Please ask for: Mrs D Johnson
Email: daun.johnson@arun.gov.uk
Telephone: 01903 737762
Our Ref: BE/16/25/RES
Your Ref:
Date: 20th February 2025

Application for Approval of Reserved Matters Following Outline Approval

Development: Approval of reserved matters following outline consent BE/150/22/OUT comprising of 3 No units within Class B2 and/or B8 of the Use Classes Order (including ancillary office provision) with associated enabling works, parking, landscaping and sustainable drainage system with access off Newlands Road. This application is in CIL Zone 4 (Zero Rated) as other development.

Location: Land At Oldlands Farm Newlands Road Bognor Regis PO22 9NN

Unit 1 Elevations

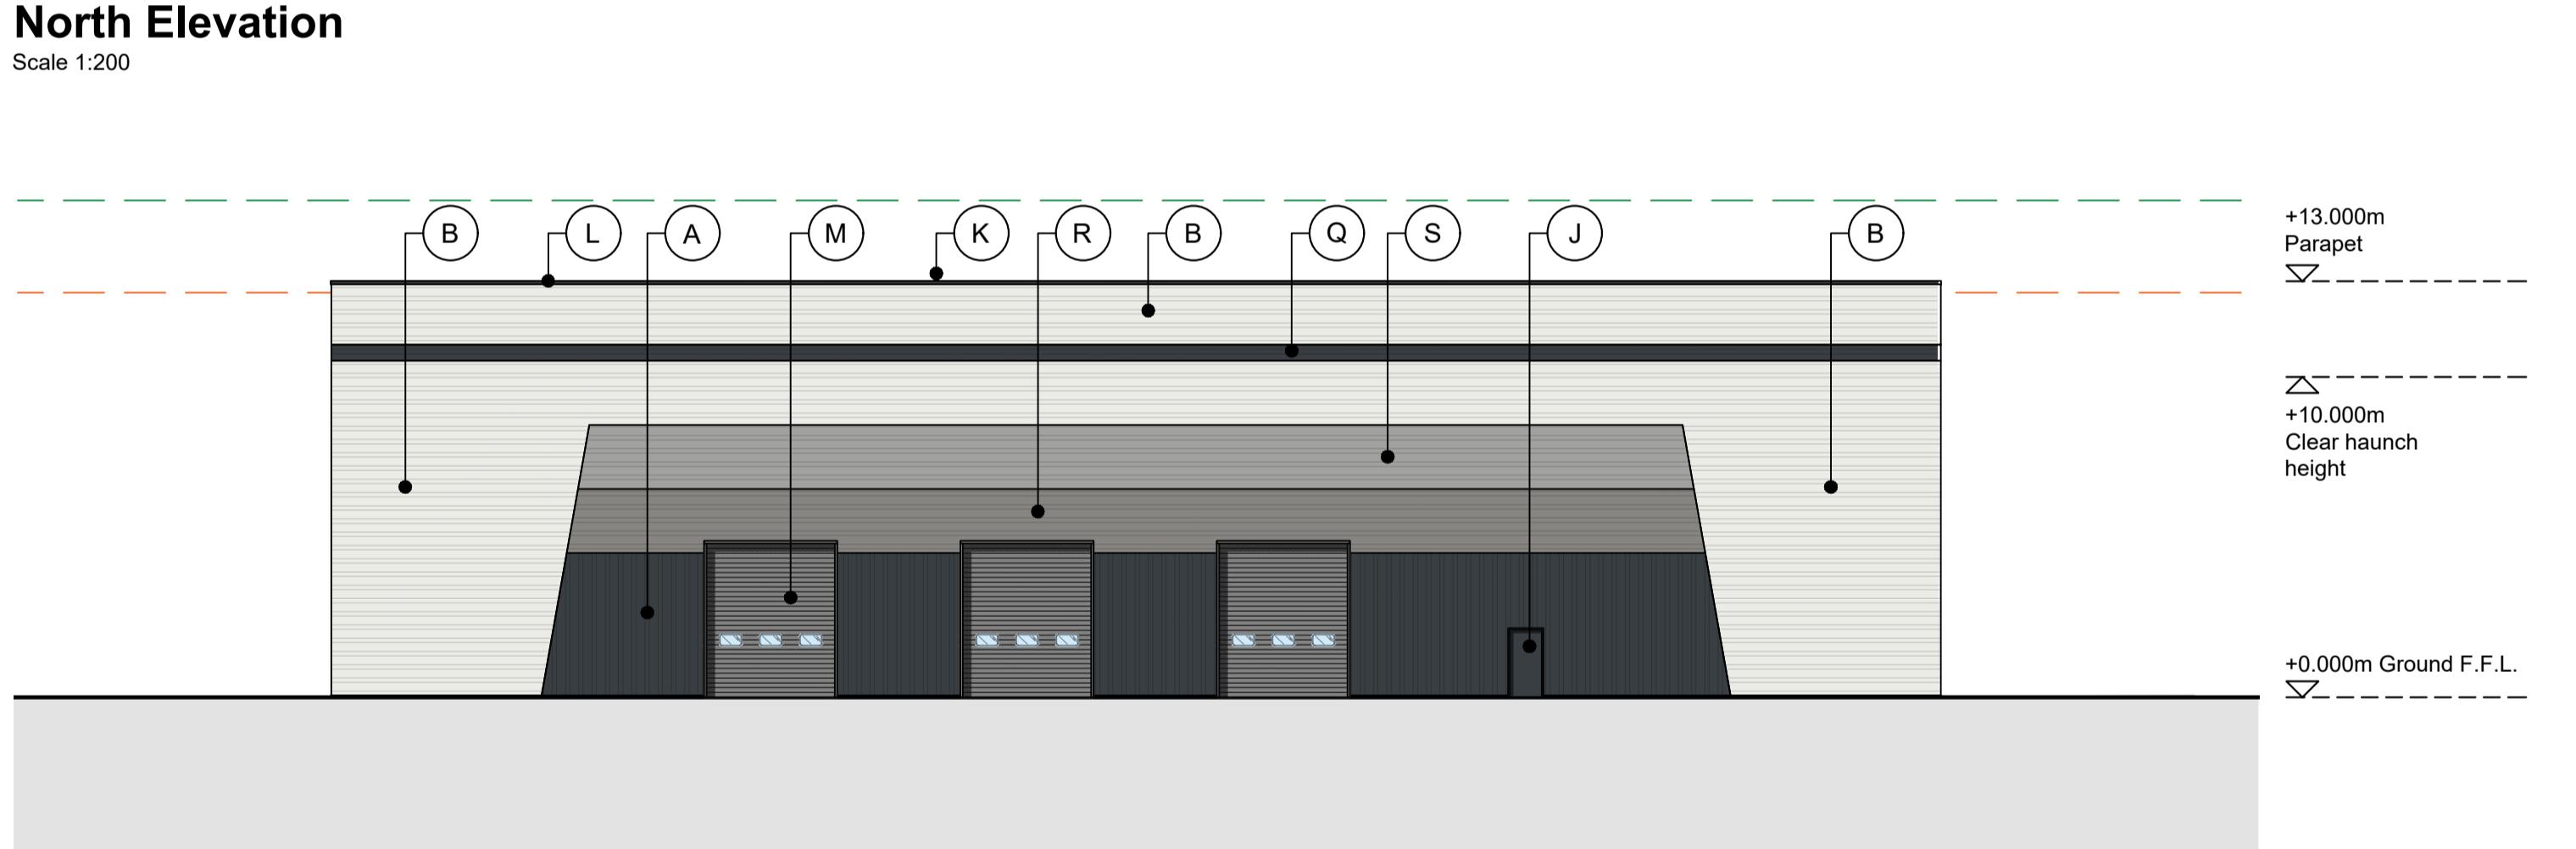
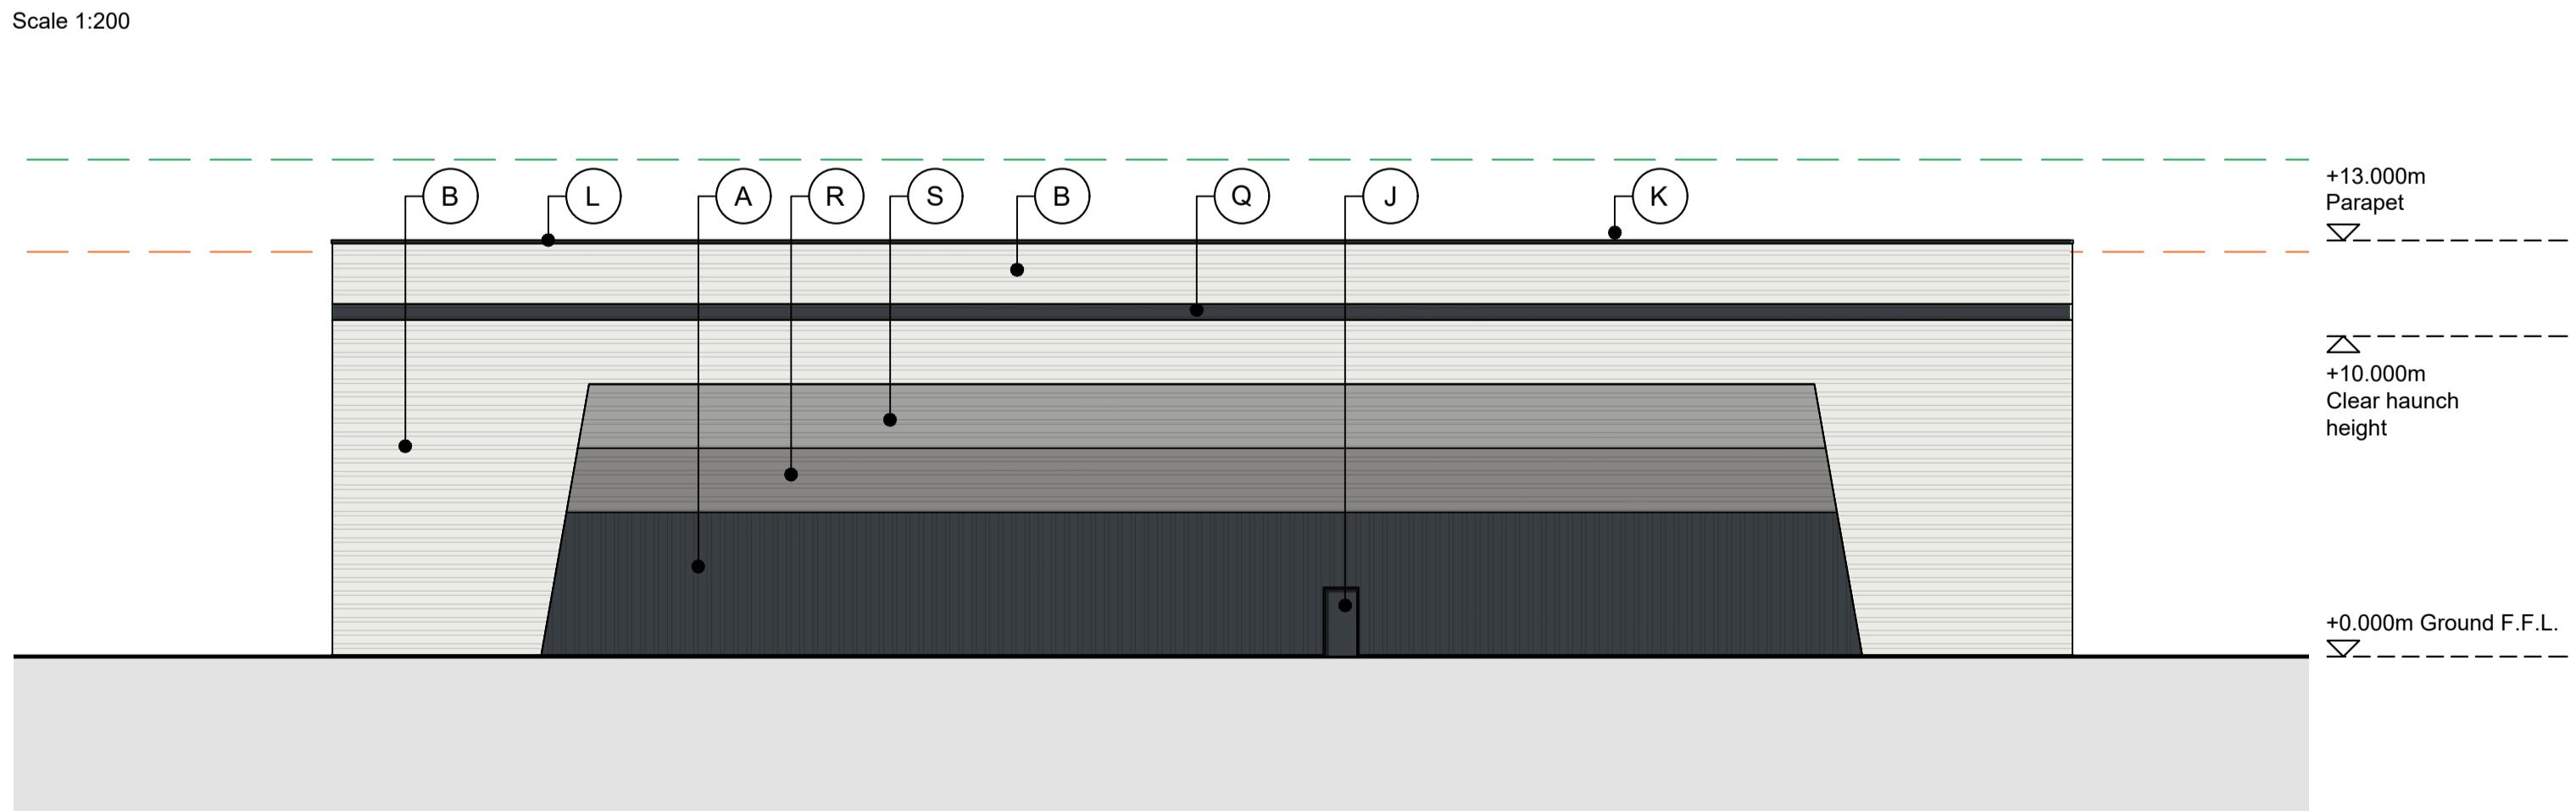
The ground floor and first floor plans and west elevation of Unit 1 do not accord. Please amend accordingly.

Unit 2 & 3 - Layout

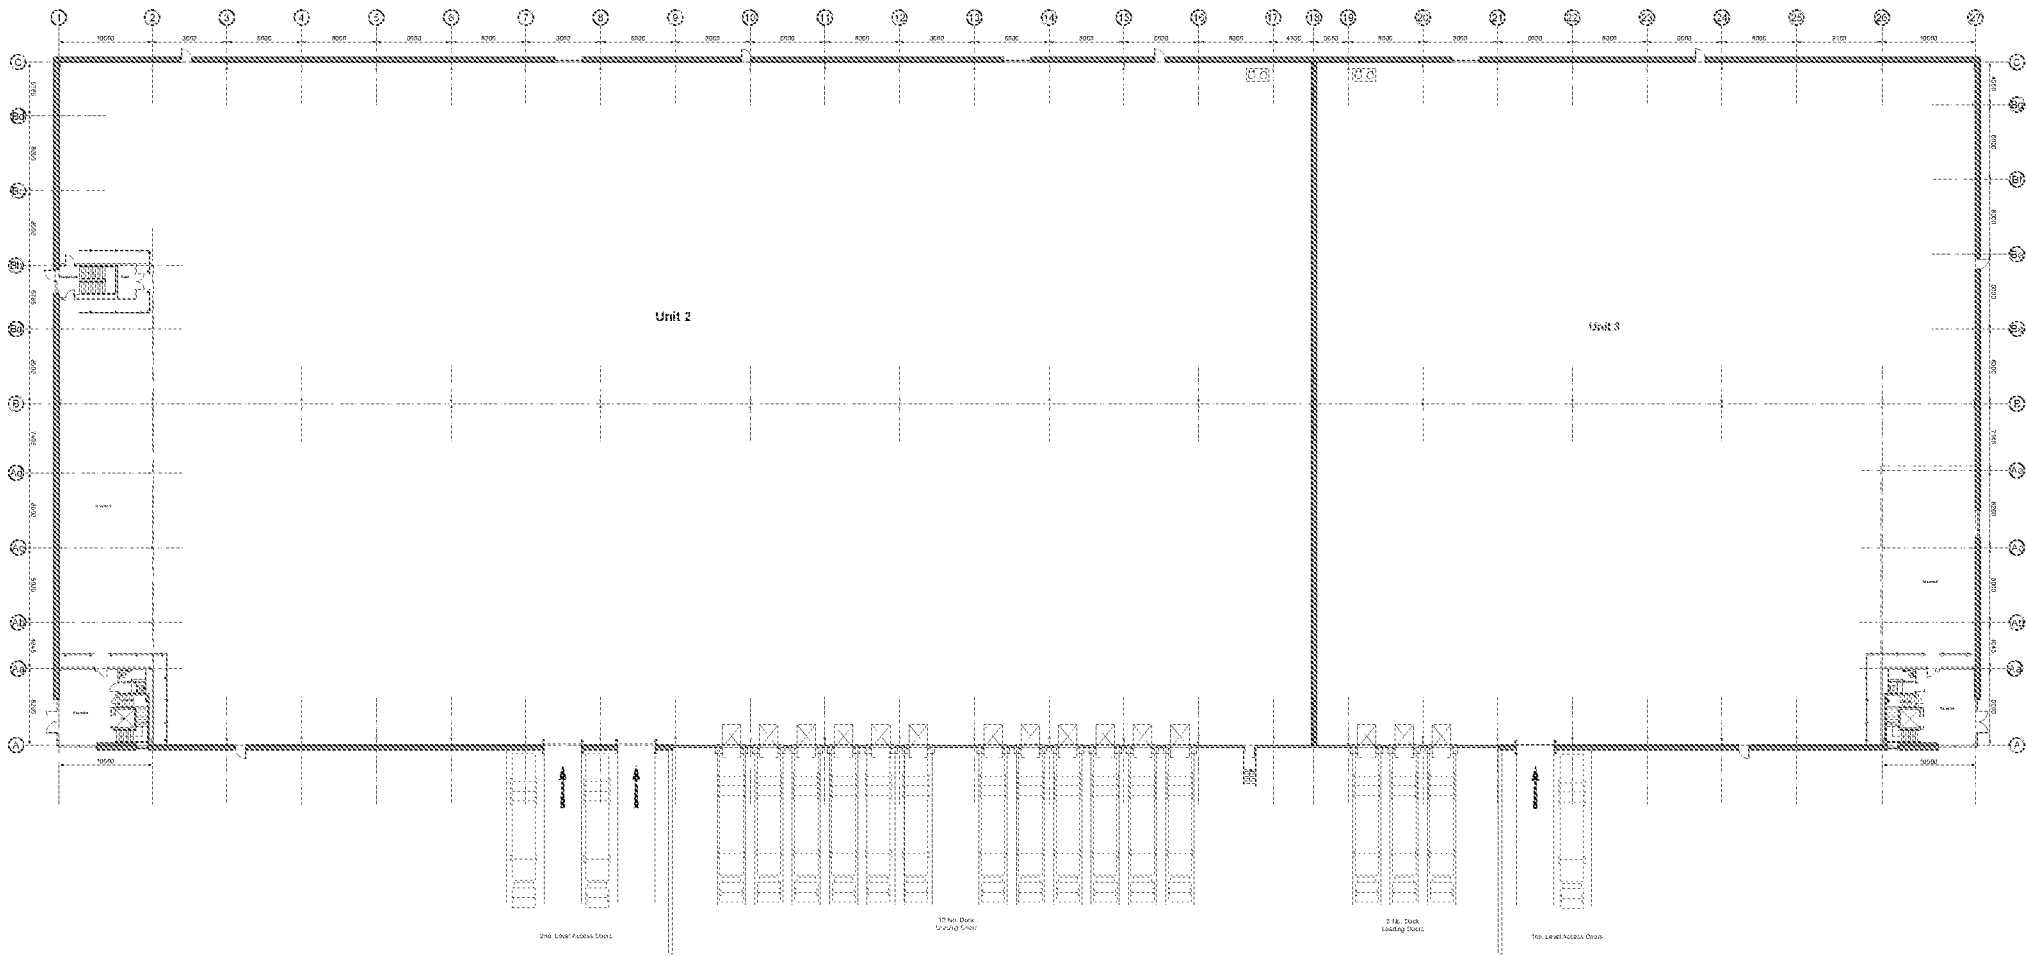
Units 2 and 3 floor plans and elevations are not scaling with each other. Please amend accordingly.
